APPLICATION FOR REMOVAL OR VARIATION OF A CONDITION FOLLOWING GRANT OF PLANNING PERMISSION (Ref: 20/02247/FULL). TOWN AND COUNTRY PLANNING ACT 1990. PLANNING (LISTED BUILDINGS AND CONSERVATION AREAS) ACT 1990.

REGENCY HOUSE, 1-4 WARWICK STREET, LONDON, W1B 5LT

On behalf of our client, Maslow's ("the Applicant"), we enclose herewith a Minor-Material amendment application to planning permission ref: 20/02247/FULL, which was approved on 18 December 2020. The approved description of development is:

Drawing Number
MS-DCM-06-DW-EL-411SW A

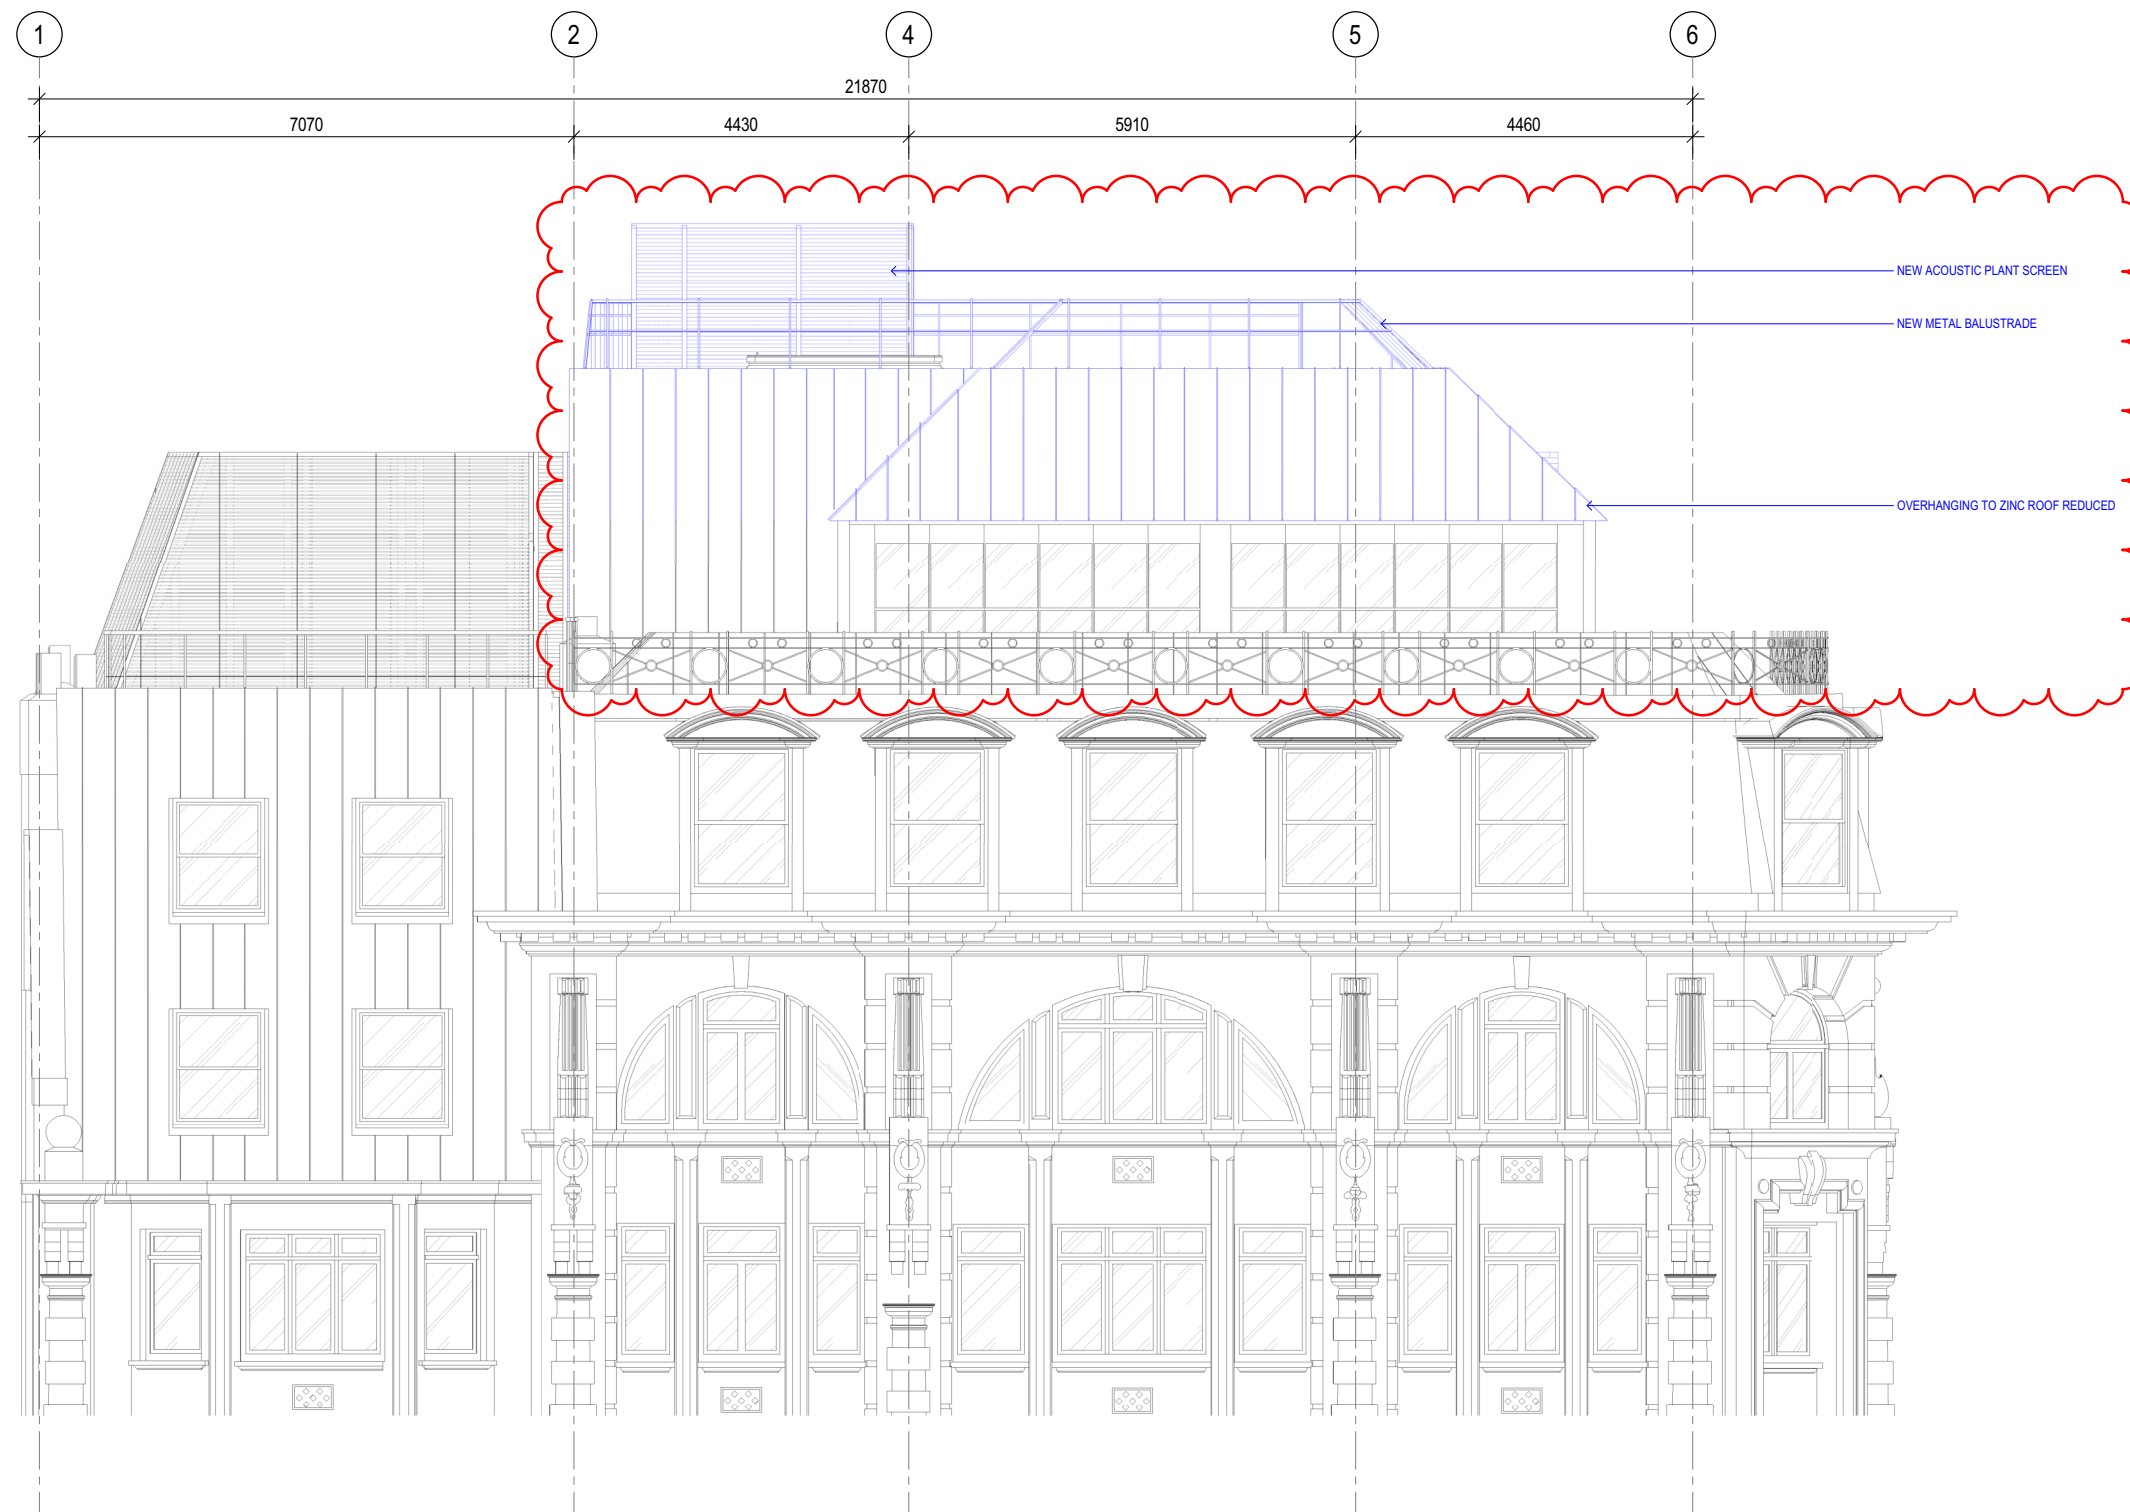
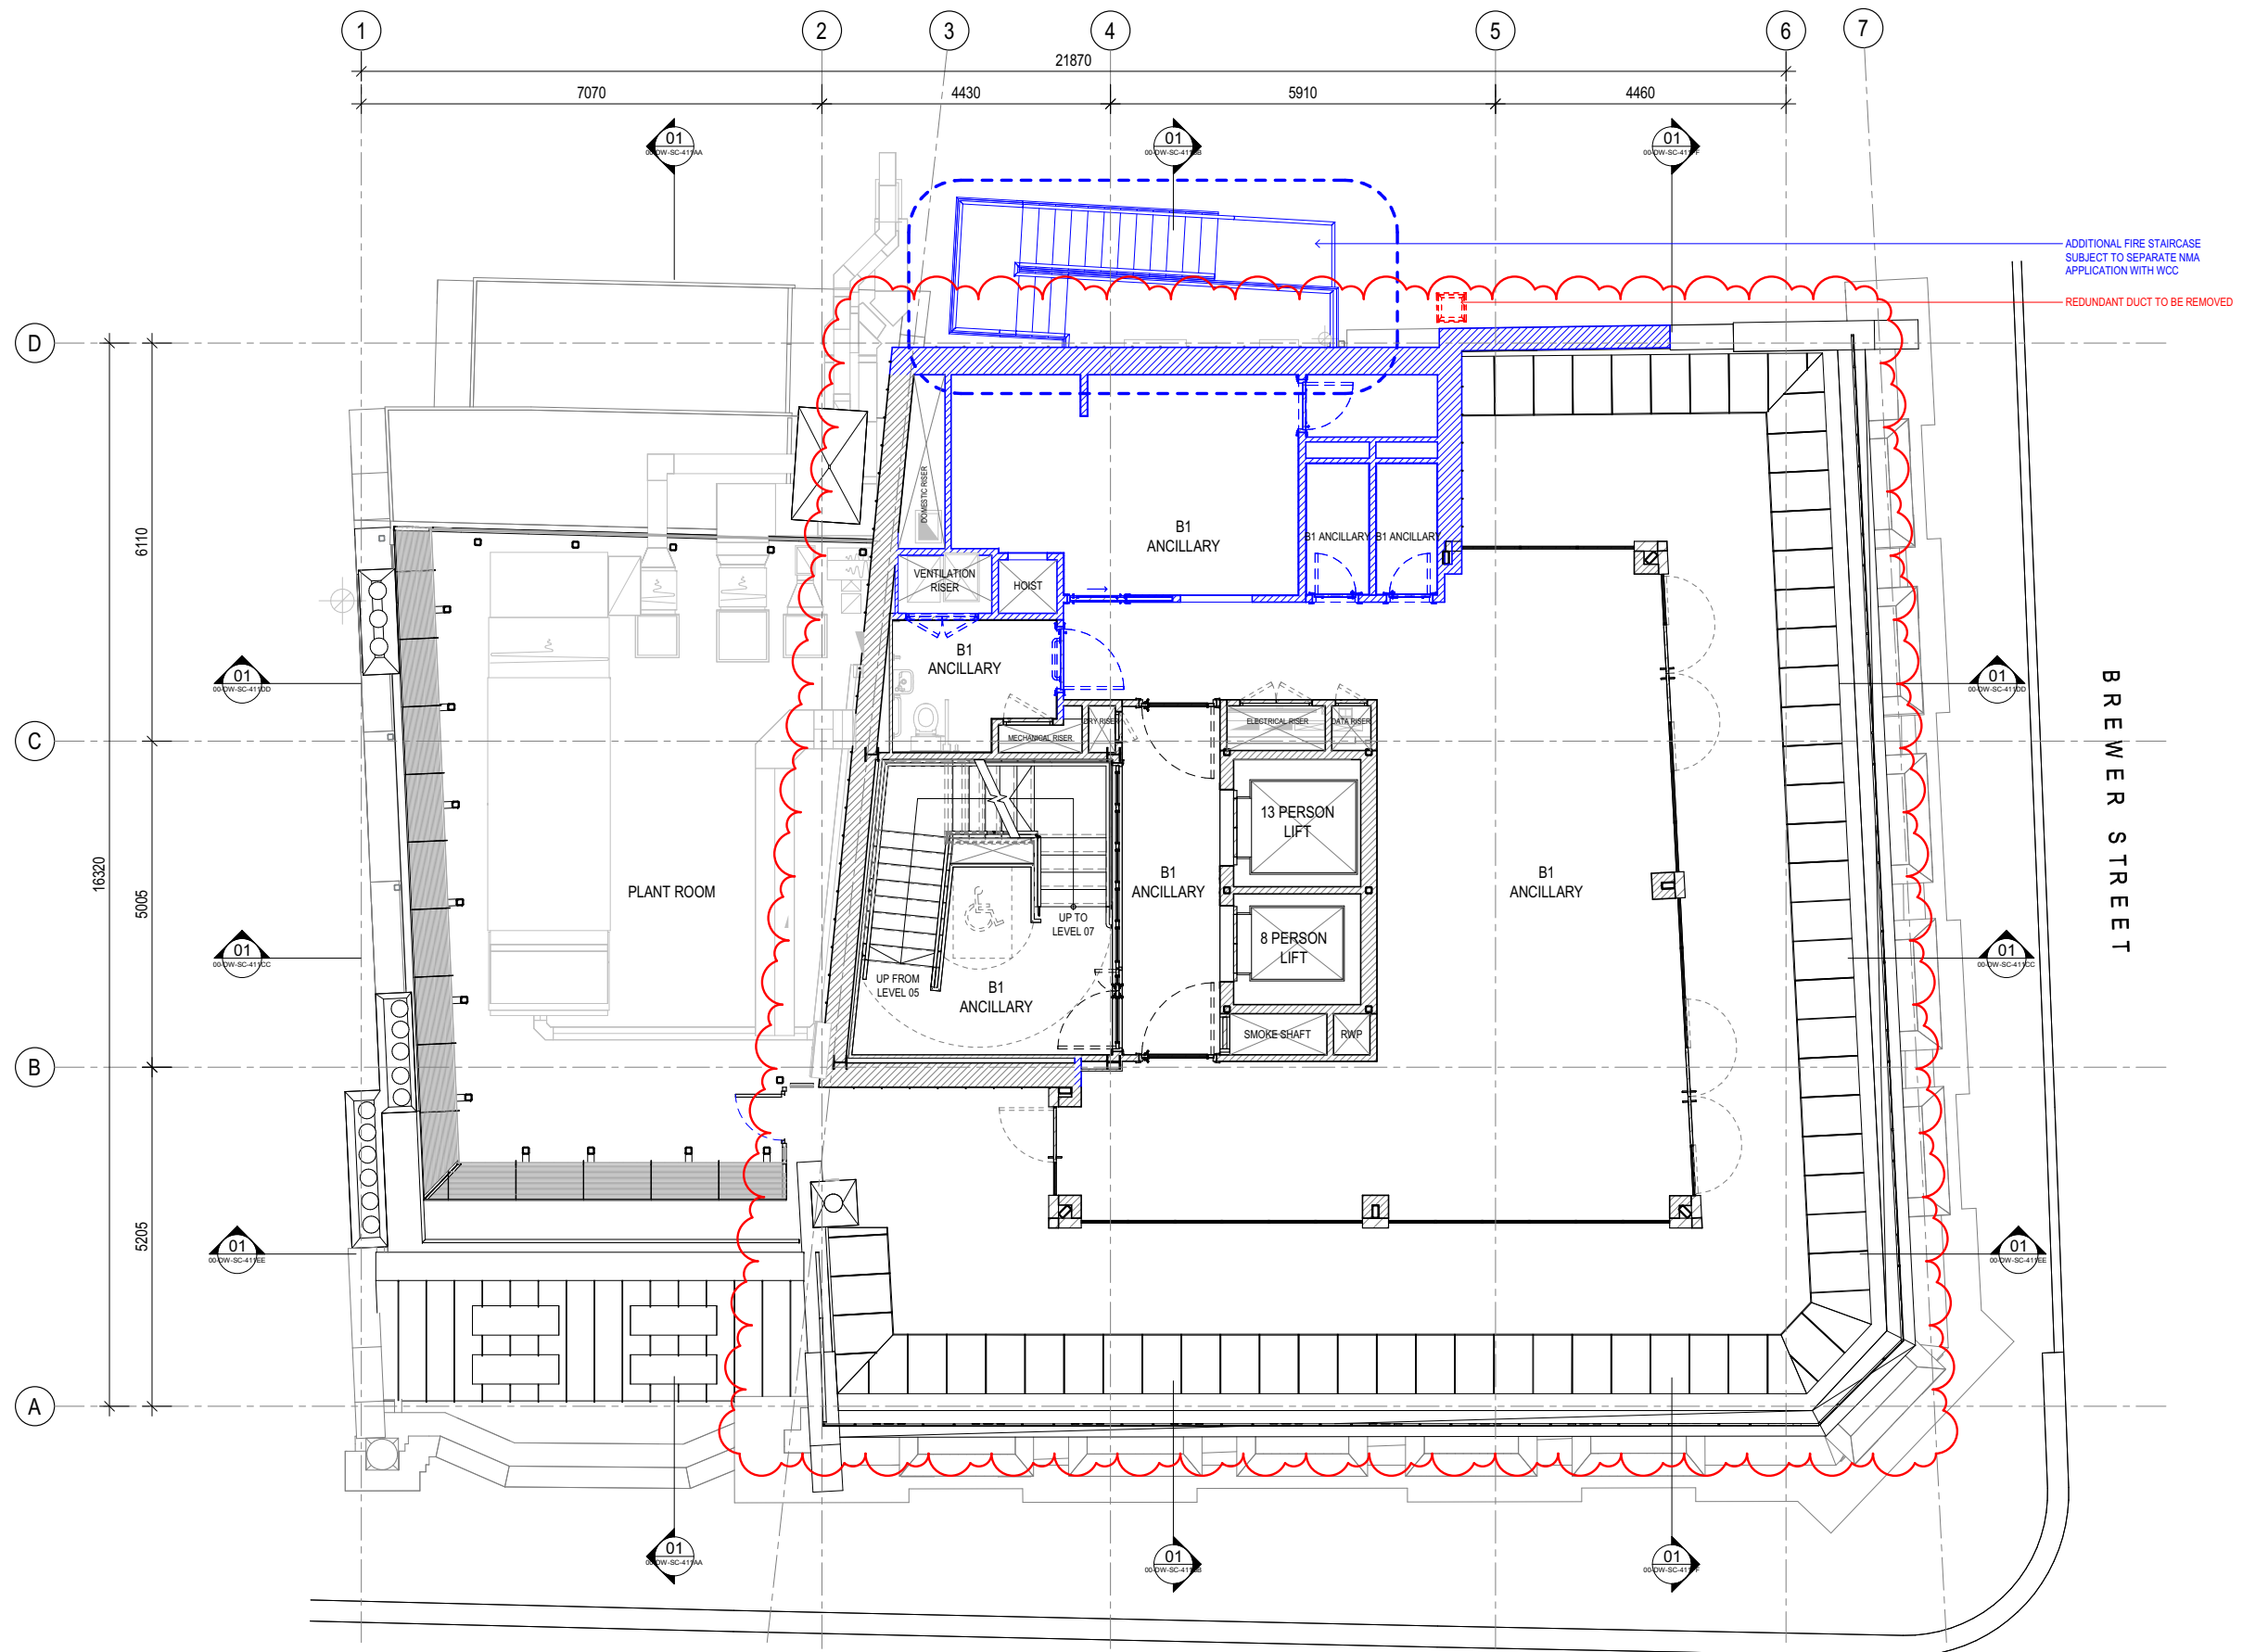
- Removal of the roof overhang to the level 06 extension, providing a more open rooftop terrace.
- Introduction of a 45-degree balustrade to level 07 rooftop which follows the building line from level 06. Item is not visible from street level.

The accompanying MMA report sets out several shortcomings with the consented terrace design. The proposed removal of the roof overhang would significantly improve the openness and usability of the terrace. The design team have worked to develop a proposal that would preserve the character and appearance of the Soho Conservation Area, whilst being considerate to the Applicants design requirements.

Drawing Number
MS-DCM-XX-DW-EL-412NE A

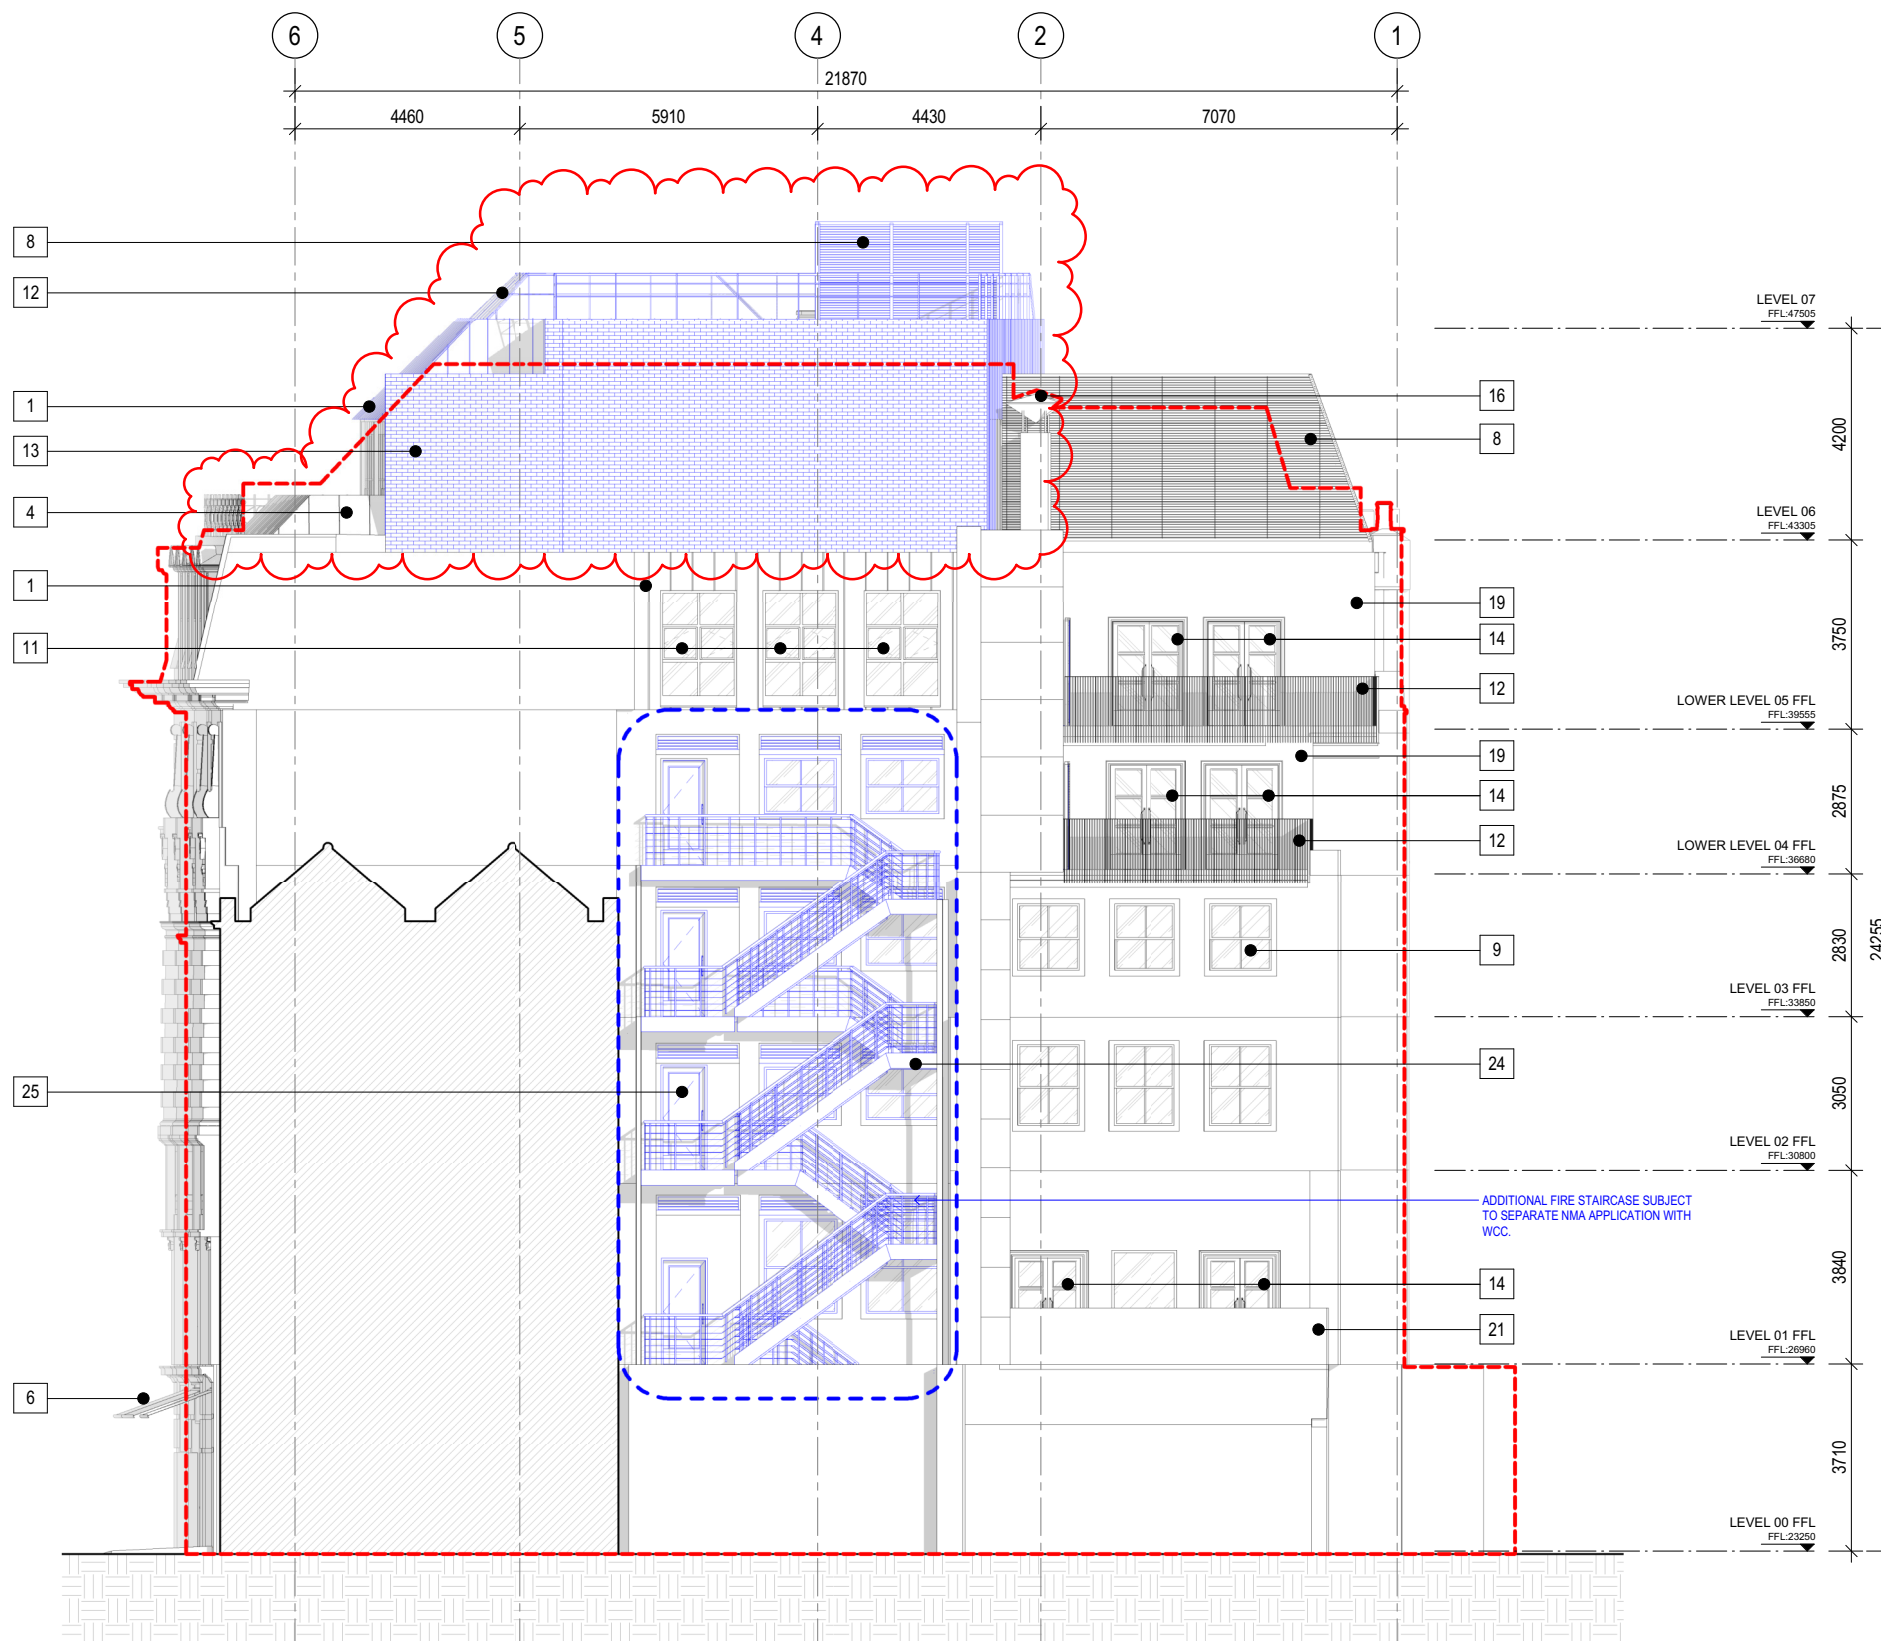
- Straightening of north-east façade to level 06. The consented layout is insufficient and restricts usable area on level 06. This is due to the consented scheme’s shallow roofline. We propose the straightening of the facade on the North-East façade to provide much needed useable footprint to the scheme. The approved area schedule remains the same.

- Existing gable wall to the north-east façade extended using reclaimed London stock brick to screen any new building whilst visually integrating it with this secondary side north-east elevation.

The proposed extension of the north-east façade gable wall upwards using reclaimed London stock brick will screen the new structure behind it, whilst visually integrating it with the rest of the north-east elevation. This proposed amendment would not adversely impact the historic fabric, architectural interest or significance of the Site and its surroundings.
